Proposed Modification - Orange Waste Project Application 09\_0025 MOD 1

We object to the proposal.

EUCHAREENA ROAD
SITE COMPARISON

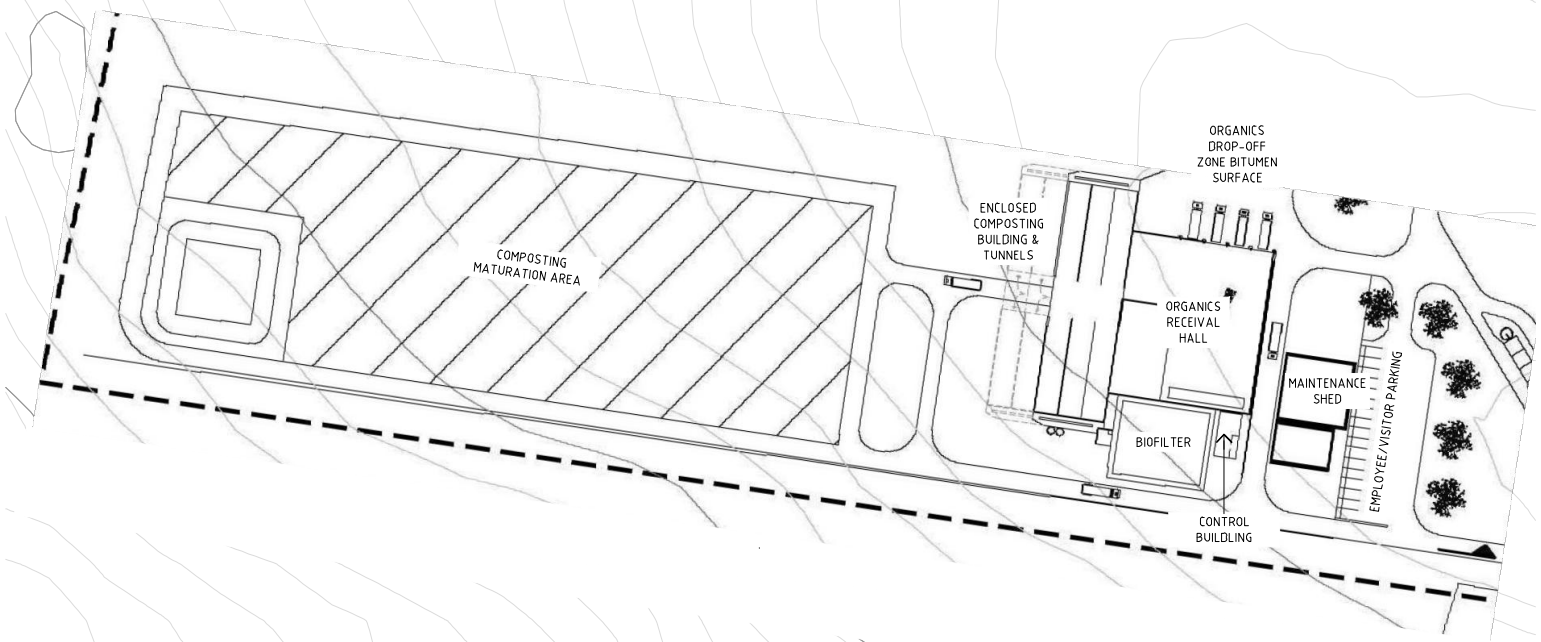
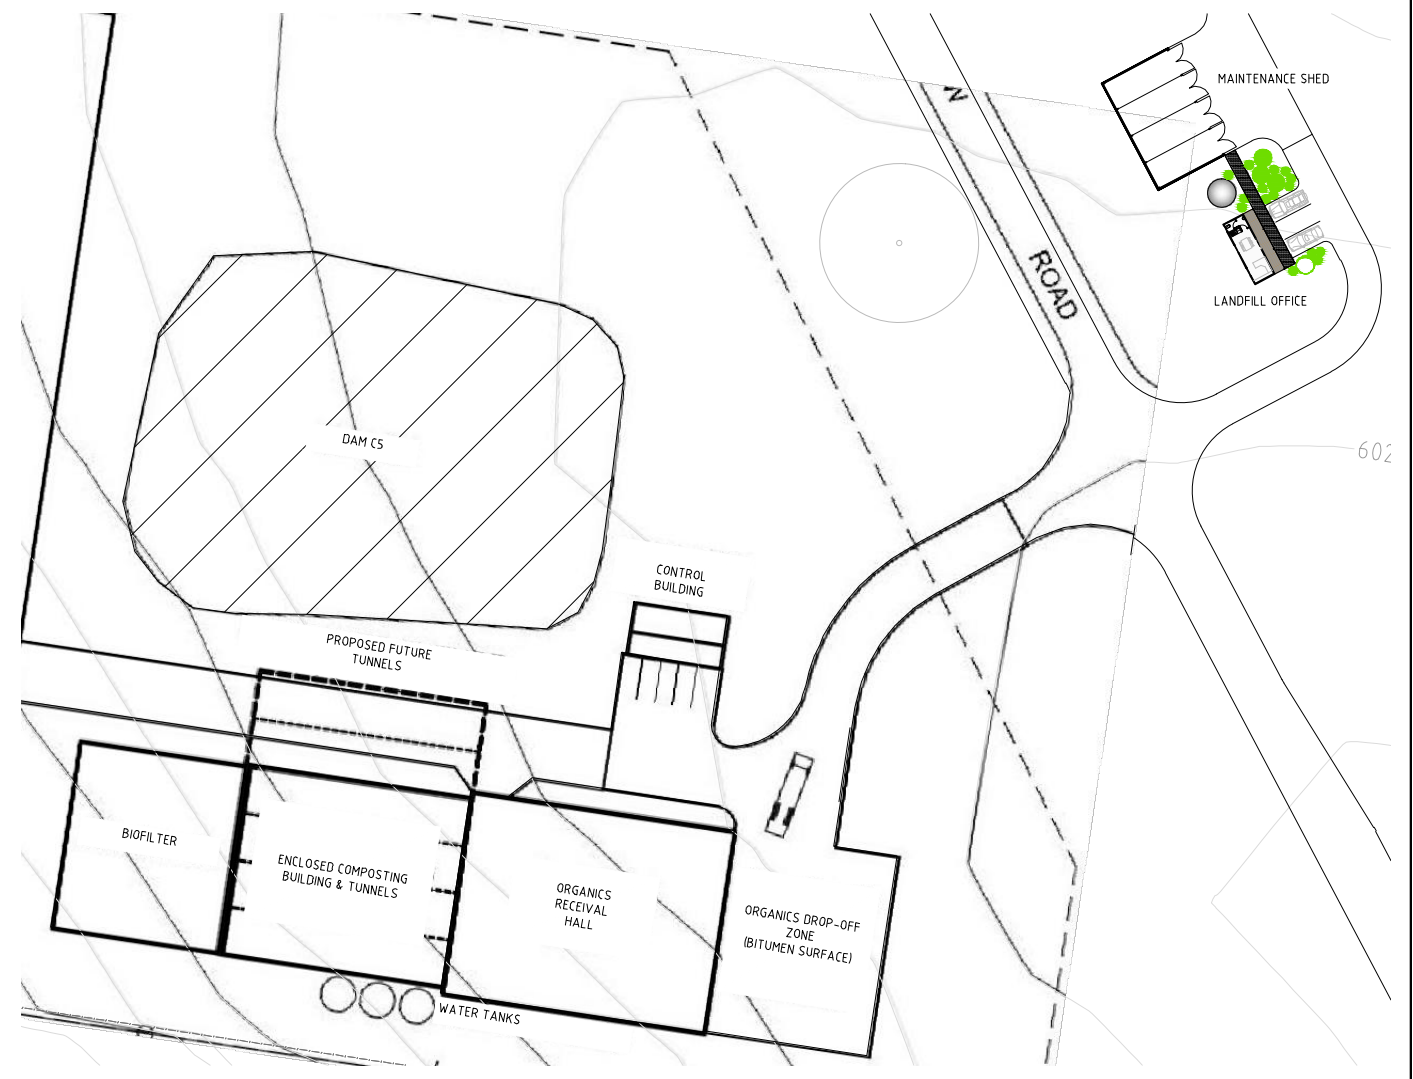
Examination of the drawings illustrating the changes to the building layouts at the Euchareena Road site indicate in both (the pre-approval and post approval) drawings, the presence of a shredder within the "Organics Receiving Hall".

Further, we are concerned about the apparent reduction in landscaping around the buildings at the Euchareena Road which were originally proposed to reduce the visual impact of the proposal from the surrounding area.

The reason for the objection is that it appears that, in respect of the proposed plan for the Euchareena Road site, some landscaping/screening trees have been removed near the composting facility. Due to the nature of the proposed development and the rural context in which it is proposed, we are concerned that no infrastructure is visible from Euchareena Road, Shades Road or neighbouring properties. We request that you impose conditions ensuring that adequate screening (including mature plantings if necessary) are established prior to commencement of construction.

The Environmental Assessment done by "Geolyse" for these so called Minor Modifications needs looking at. In this Assessment (MP\_0025) the drawings EV13 and EV14 identify the Euchareena Road Site changes. The Previous approved site plan and the Proposed site plan vary greatly if you look at the Drawings. The Proposed Site Plan (Drawing EV13) shows a big change to the Screen Bunds and the surface run off Dams A, B and C have also disappeared. None of this is mentioned in the notes to this modification. Surely after being allowed to do away with the Leachate Ponds in a previous modification, the surface water run-off Dams need to stay.
